THE HILLS SHIRE COUNCIL
3 Columbia Court, Norwest NSW 2153
PO Box 7064, Norwest 2153
ABN 25 034 494 656 | DX 9966 Norwest

8 October 2020

Our Ref: FP223
Your Ref: SSD-9653

RESPONSE TO SUBMISSIONS – SHOWGROUND STATION PRECINCT STATE SIGNIFICANT DEVELOPMENT APPLICATIONS (REVISED CONCEPT)

Figure 4. Proposed new street section in precinct east

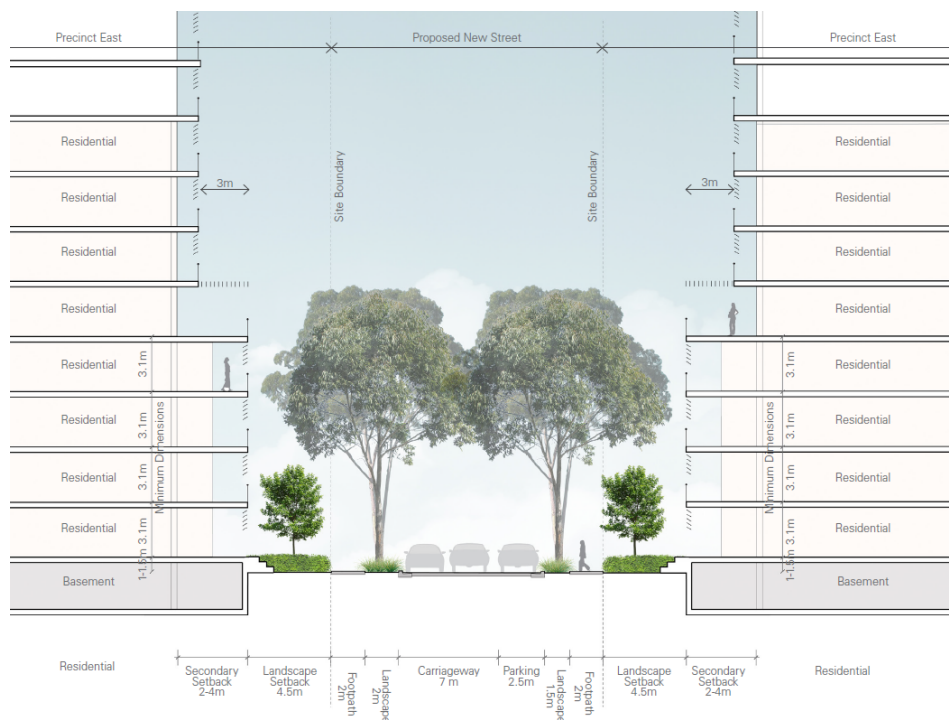
- The current urban design concept retains 3 metre upper level setbacks. As per Council's submission, it is recommended that the minimum upper level setbacks within the Doran Drive Precinct and Precinct East be 5 metres.
- Precinct East New Street: The balconies above the 4 storey podium should not protrude into the secondary setback area.
